From: [Cllr Langford-Smith](#)
To: [Aquind Interconnector](#)
Cc: [Cllr Andreoli](#); "SCornwell@winchester.gov.uk"
Subject: Comments for the Open Floor (7th Dec) and Issue Specific (9th Dec) Hearings
Date: 30 November 2020 15:39:36
Attachments: [1\) Village Legacy.docx](#)
[2\) Preservation of Gap.docx](#)
[3\) Impact on SINC.s.docx](#)
[4\) Impact of Building.docx](#)

Paula Langford-Smith
Chairman
Denmead Parish Council

Remarks to Aquind Hearing on Impact on SINC's 09-12-20

Remarks to Aquind Hearing on Impact of the Buildings 09-12-20

Plate 6.3 – Denmead Meadows Mitigation Strategy Map

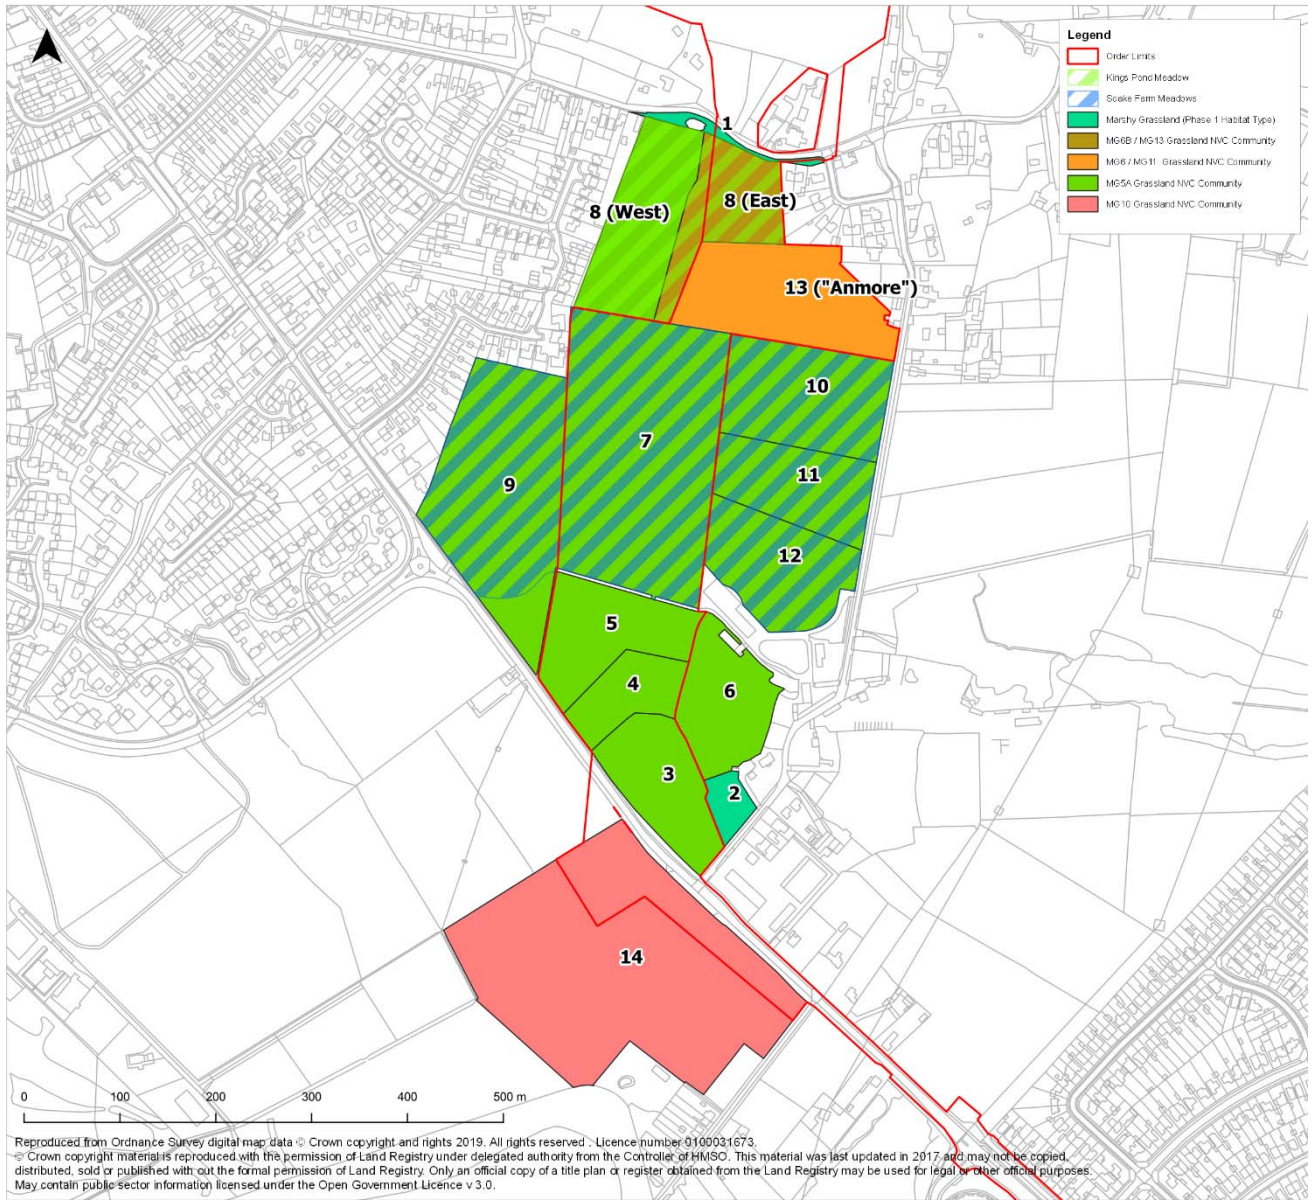
The Draft Development Control Order and plans presented by the developer call for two compounds to be established at either end of the meadows between the Hambledon and Anmore Roads in Denmead Parish to enable the drilling works which will install the interconnector cables under said meadows.

There is still some doubt as to where the compound will be situated at the Hambledon Road end, but the Anmore Road proposal is for the entrance to the compound to be 15 metres wide to the south of Anmore Road into the meadows which are being protected by drilling instead of trenching!

This 15-metre entrance is in addition to the width of cable run being drilled. This will result in the loss of more than 20 metres of hedgerow on the south of Anmore Road. Whilst this can be replanted, it will take many years to recover the look of the area.

The whole of the meadow area between Hambledon Road and Anmore Road is designated as a Site of Importance in Nature Conservation and so this northern compound is being proposed on the very land that the drilling operation is meant to protect.

If the compound on the Hambledon Road is also placed in the meadows then both compounds will be built on the SINC land, causing severe damage and destruction of protected natural habitats.

If the drilling operation was carried out to and from the north side of Anmore Road, then the northern part of the SINC would be protected, and there would be no requirement to trench the cable across the Anmore Road, also saving many weeks of disruption on this narrow rural lane.
